Application Reference Number: WWO10001

Examining Authority's Second Written Round of Questions and Requests for Information Response from Thames Water

**Code of Construction Practice Part B: Site Specific Requirements
- King Edward Memorial Park Foreshore (Compare against 23 September 2013)**

Doc Ref: **APP72.19**

**Document Information**  
**Application for Development Consent**  
Construction phases - phase 2  
Shaft construction  
Book of plans - section 25  
DCO-PP-24X-KEMPF-250016  
January 2013

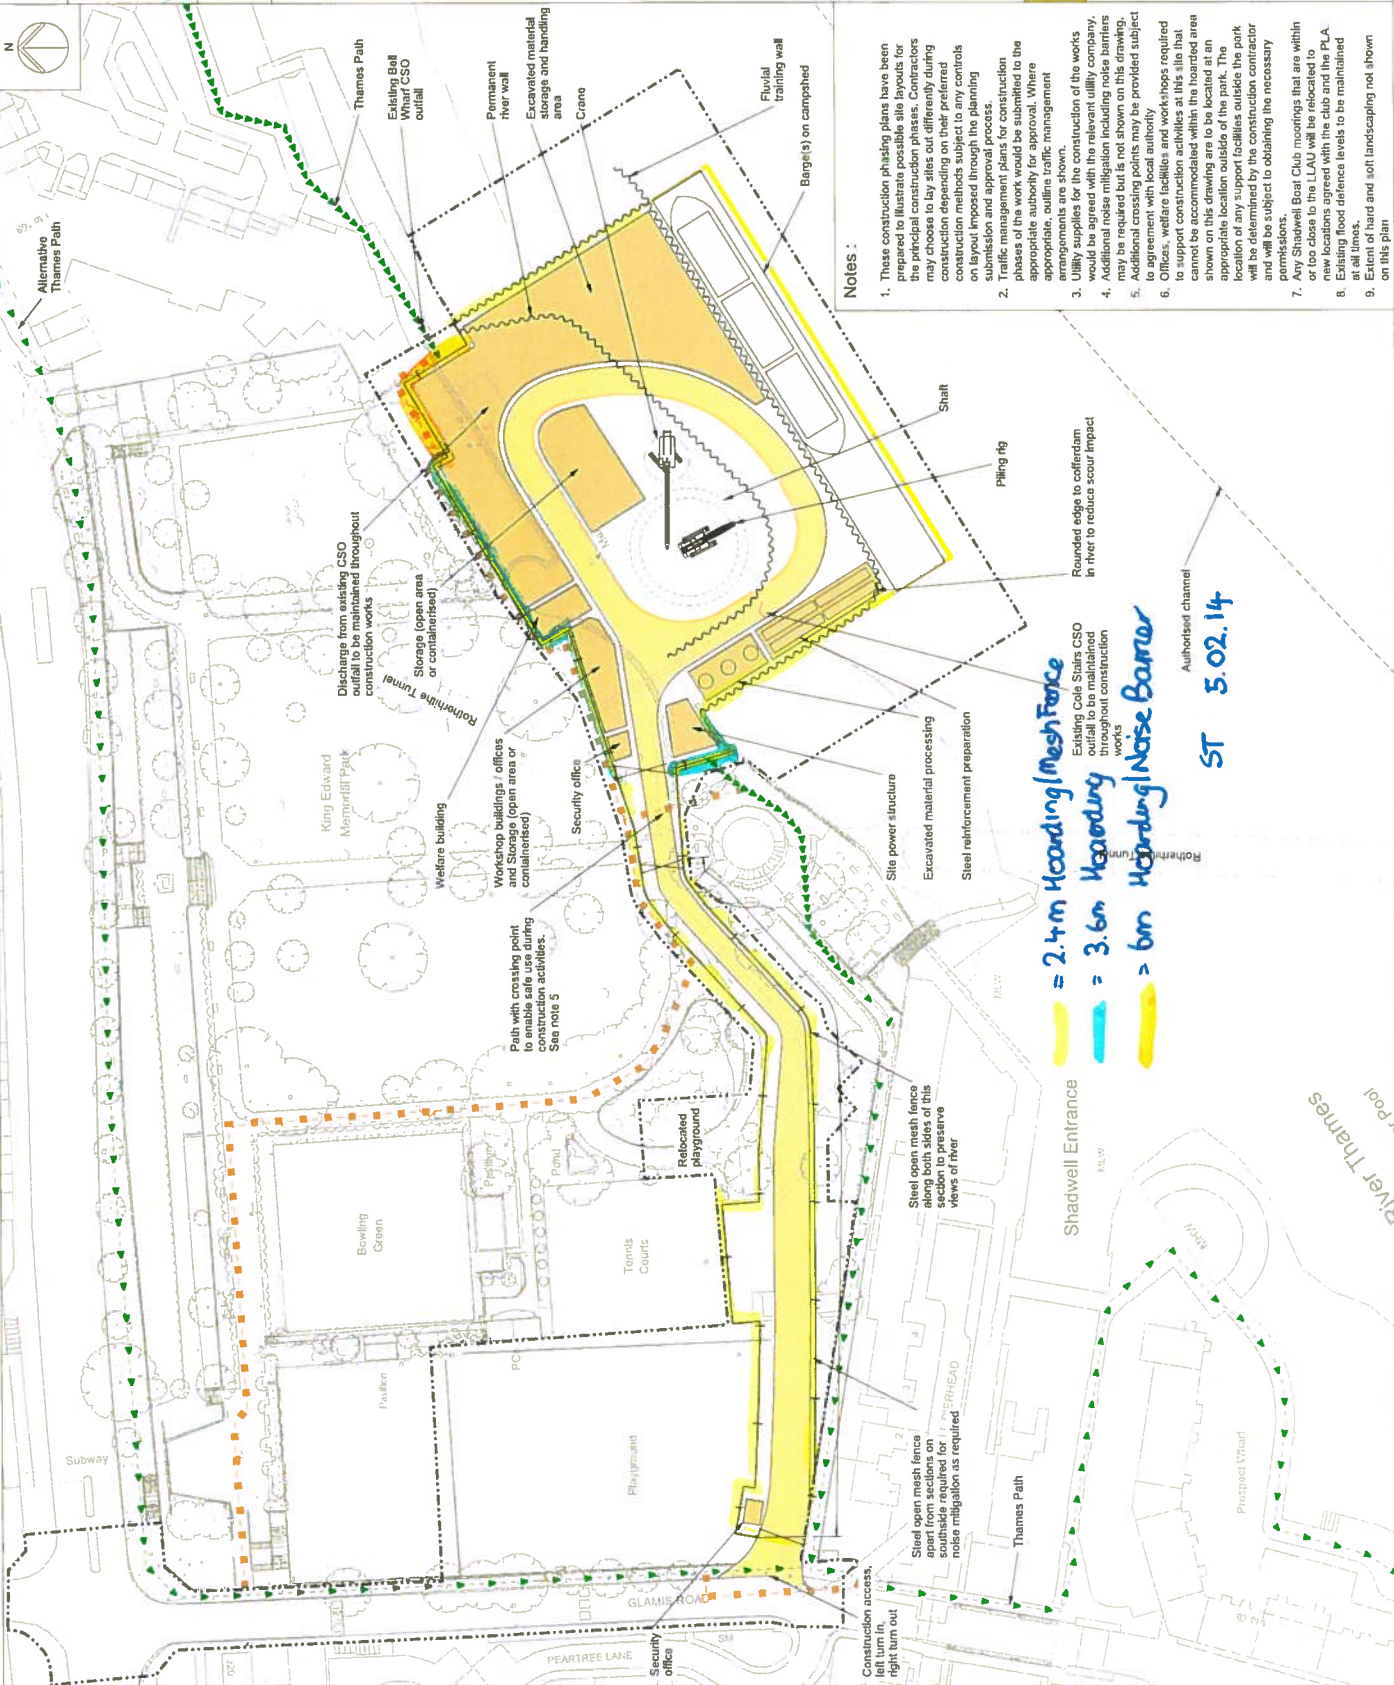
Site security / hoarding requirements	<p>The hoarding is to be as defined in <i>CoCP</i> Part A para. 4.3.4c, <u>2.4m high</u> planted hoarding on public facing sections. The areas around the shaft construction site and the multi sport/park maintenance site are to have full standard 2.4m hoarding.</p> <p>The site vehicle access route <u>between the relocated junior play area and the Rotherhithe Tunnel Ventilation Shaft</u> is to have secure, <u>2.4m high</u> green painted steel open mesh fencing to allow views through to the river to be maintained.</p> <p>Outside of approved working hours and within park opening hours the steel mesh fencing on the access</p>

Topic	Site-specific requirement
	<p>route, between the relocated children's junior play area and the Rotherhithe Tunnel Ventilation shaft, willshall be removed to allow for open access through the park to the river frontage.</p> <p>A gated crossing willshall be provided to enable the realigned Thames Path to cross the access road. The gates willshall only be closed to pedestrians and cyclists during vehicle movements. A traffic marshal willshall be deployed to ensure the safe movement of vehicles and public crossing.</p> <p>Hoardings to be increased from 2.4m to 3.6m around the main shaft working areas.</p>
<u>River works</u>	<u>As per text in CoCP Part A.</u>
Other items	<p>Landscape plans to show retention of both tennis courts and a reduced multi sport pitches size.</p> <p>A site-specific lighting <u>management</u> plan is required. The lighting will<u>management plan shall</u> address the impact on terrestrial and aquatic ecology and include the use of low level directional lighting where possible whilst meeting safe work requirements. The Lighting <u>Management</u> Plan is to be submitted and agreed with<u>to the London Borough of Tower Hamlets for approval with respect to potential external impacts.</u></p> <p>Site cabins and welfare facilities to be dark green color to tie in with the planted hoardings.</p> <p><u>Site office and welfare facilities shall not be located on the sports pitches.</u></p>
